Harnett County Environmental Health

EXISTING SYSTEM APPROVAL

Proposed Property Improvement: ACCESSORY BUILDING DETACHED GARAGE OR SHOP

24' x 35' Mental Storage / Recreation

1023 Sheriff Johnson Rd.

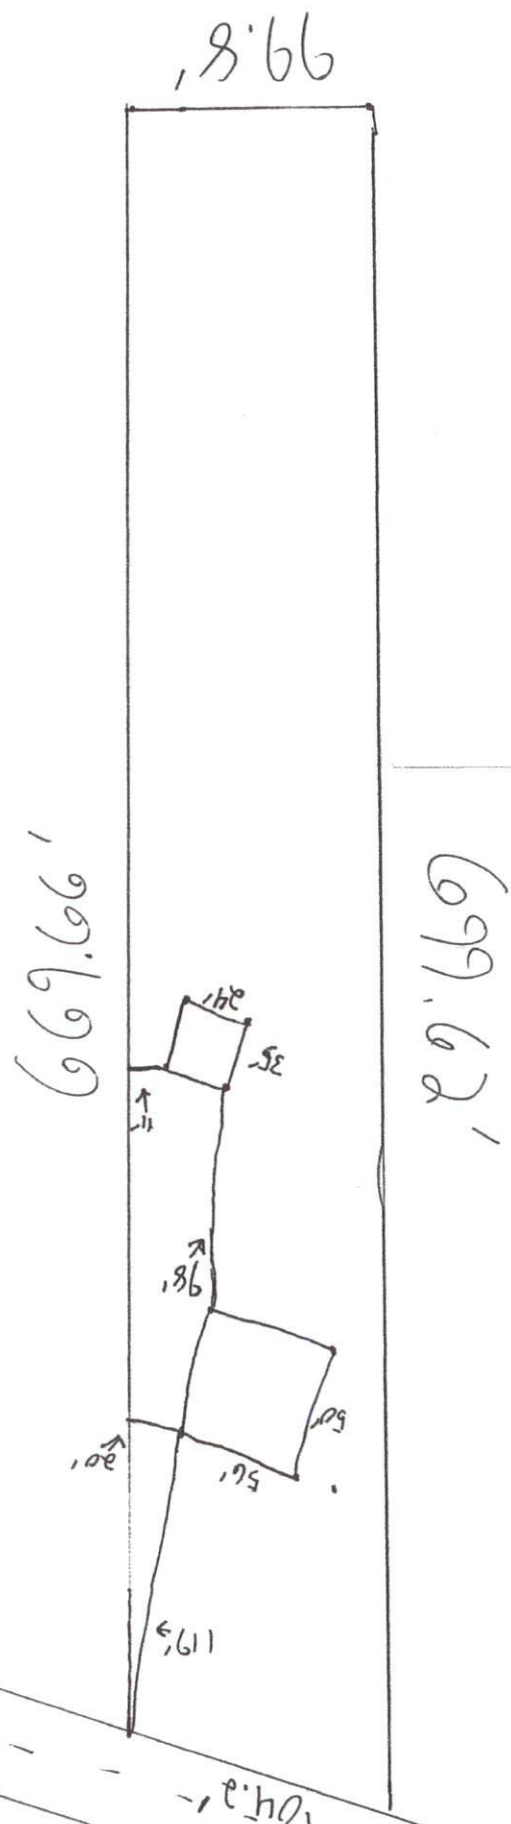
Approval Conditions: When installing proposed 24' x 35' Mental Storage / Recreation, Stay off drain lines to avoid damaging system.

There is to be no driving to and from shed at all times to avoid damaging drain lines.
